REFUSAL OF PLANNING PERMISSION

APPLICATION NO. 2019/0401

Proposal Erection of a dwelling with associated landscaping.

At Green Bottom Farm, Barnsley Road, Hoylandswaine, Sheffield, S36 7JA

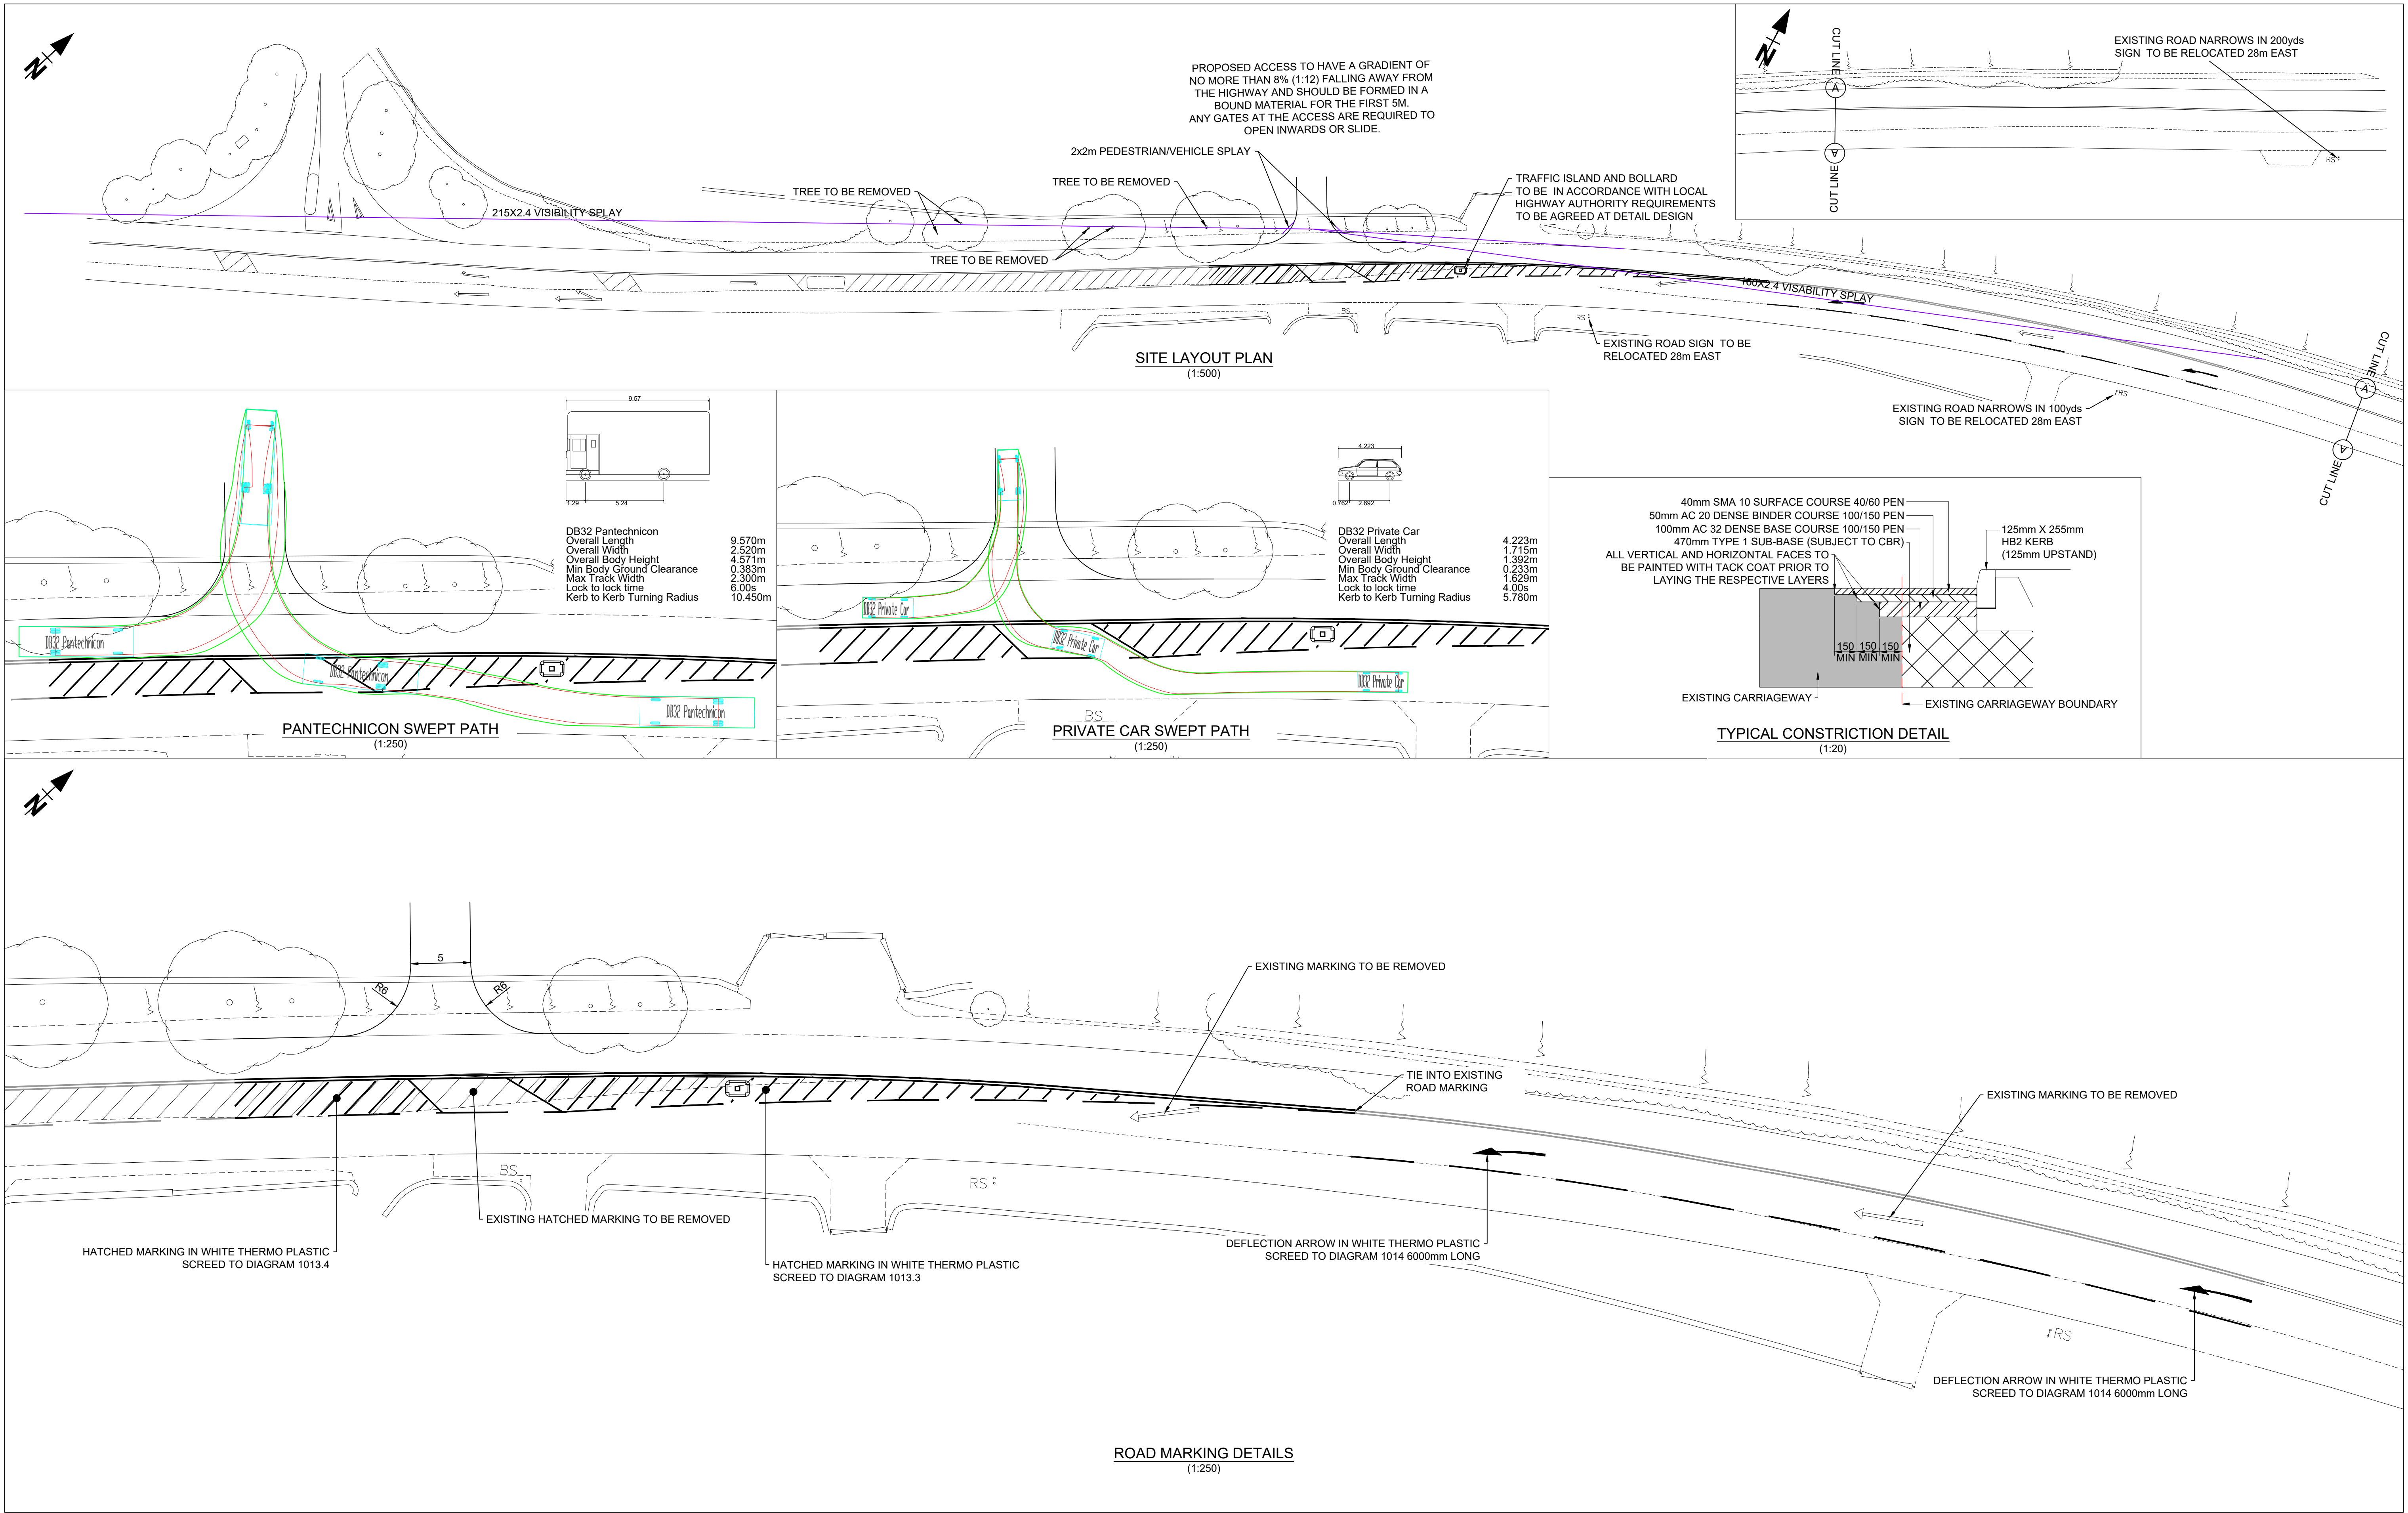
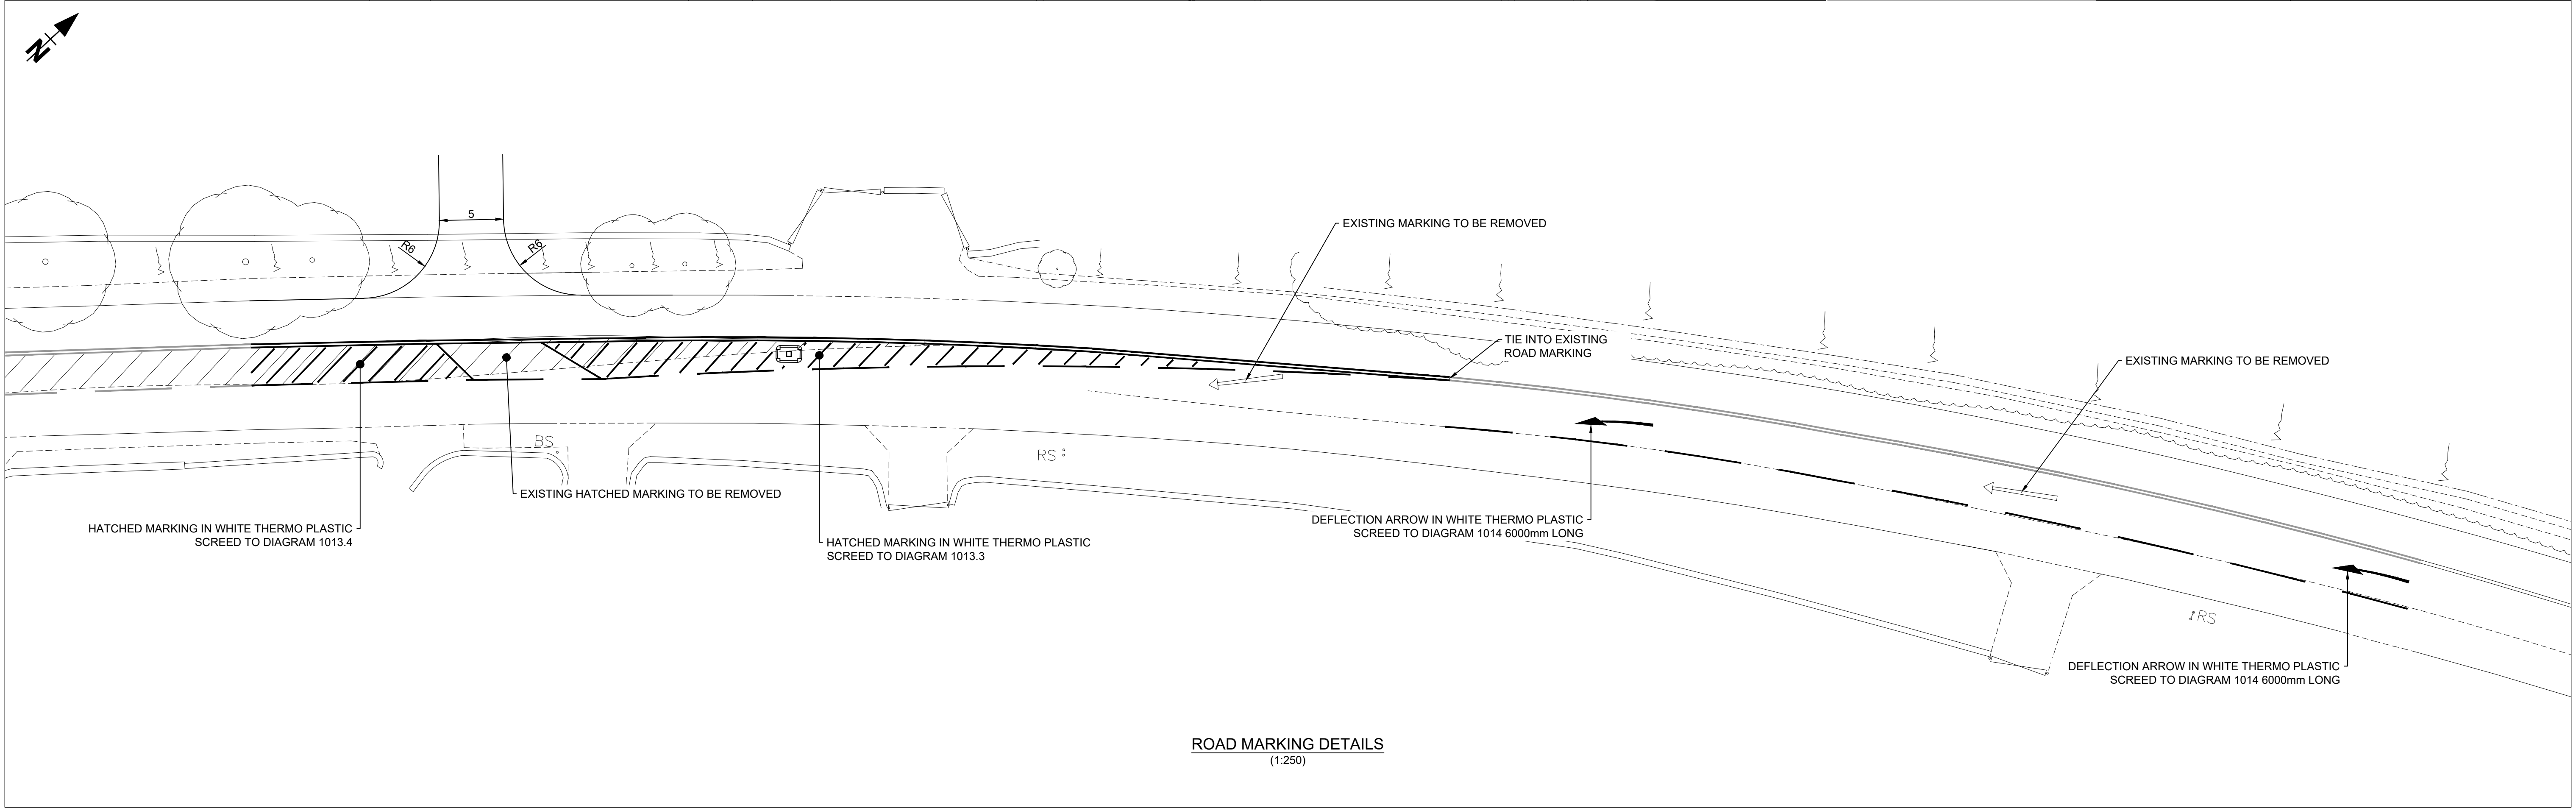
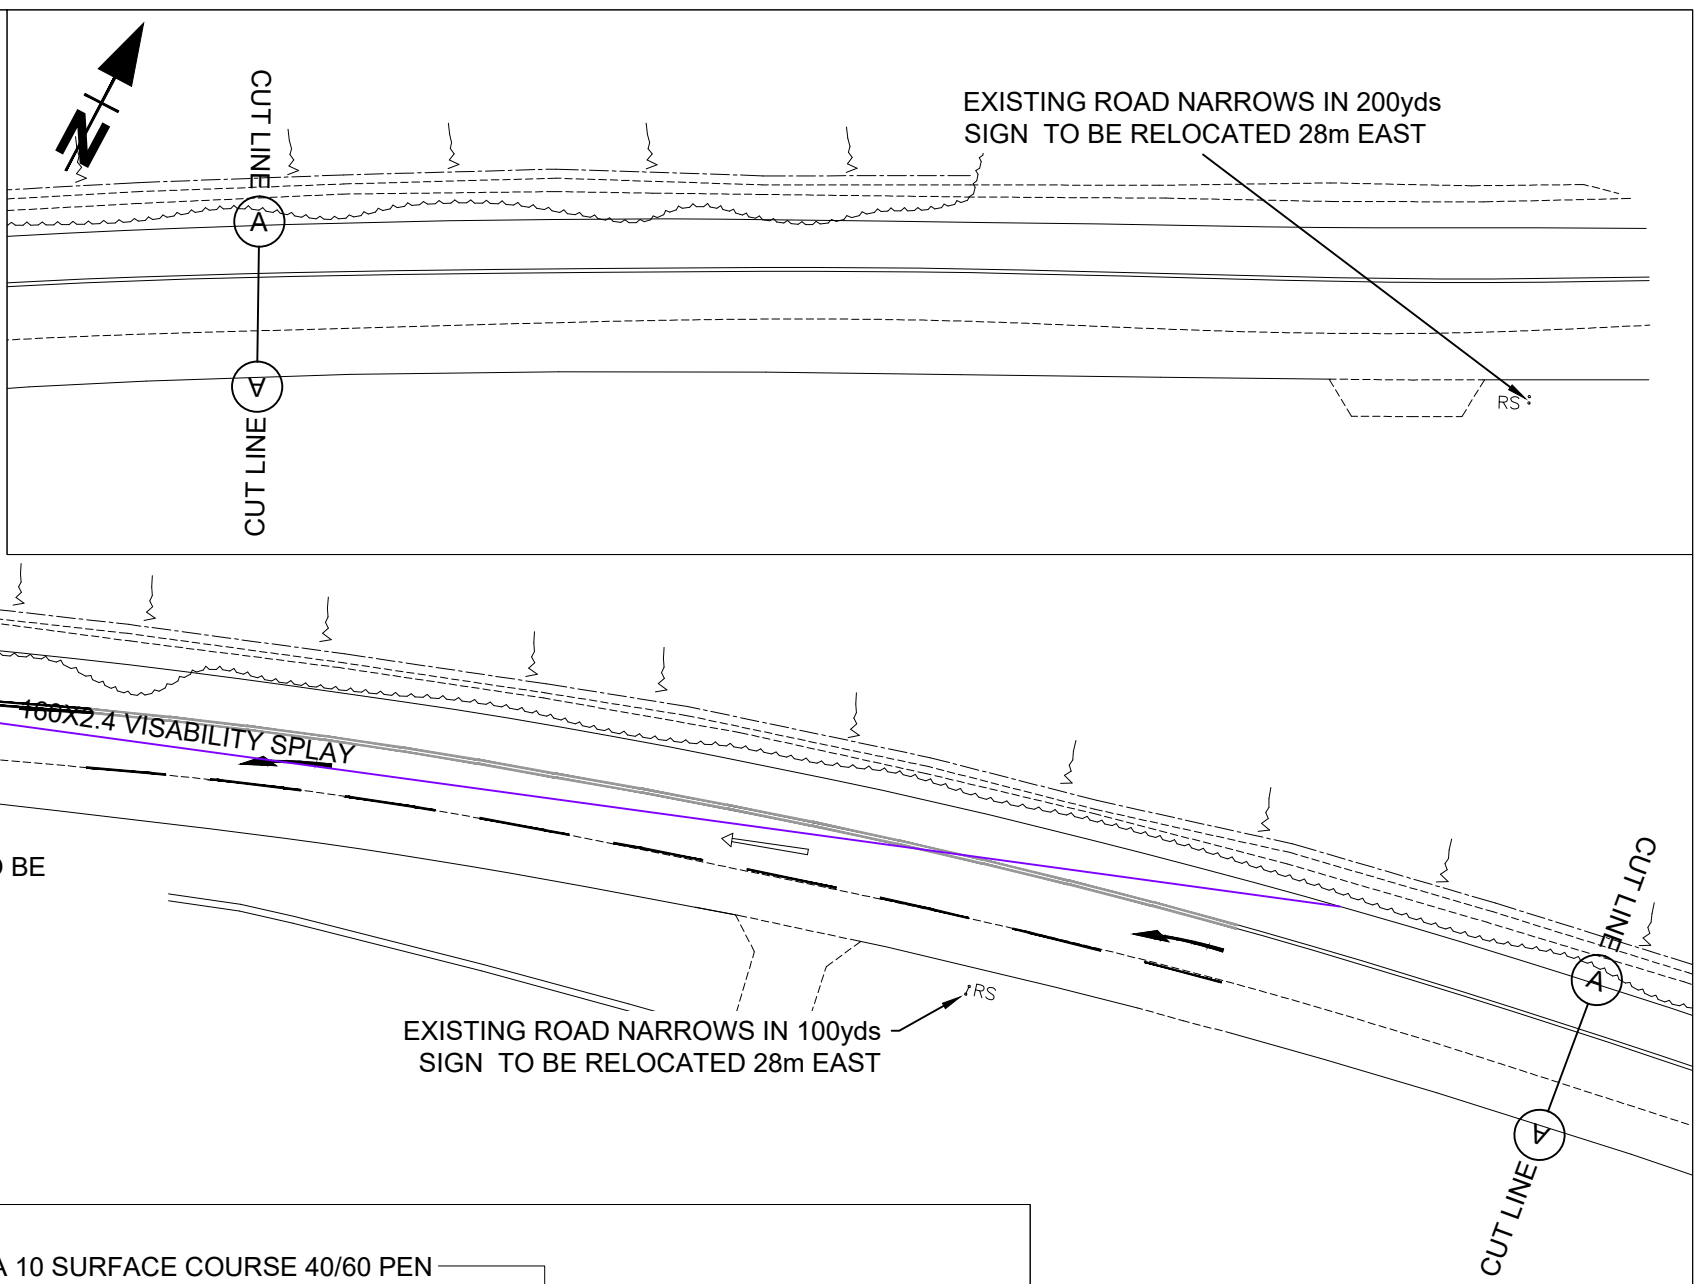
4	The proposed development would give rise to conditions prejudicial to highway safety due to the restricted visibility and introduction of an island and right turn lane, at the proposed point of access onto the A628 Barnsley Road a derestricted busy arterial road where there is a history of collisions contrary to Local Plan T4 New Development and Transport Safety.
5	In the opinion of the Local Planning Authority, the close proximity of the proposed development to the mature ash tree, would be likely to result in damage to and felling of the tree contrary to the provision of Local Plan Policy BIO1. The loss of the tree, which makes a positive contribution to the local townscape, would materially harm the visual amenity of the area.
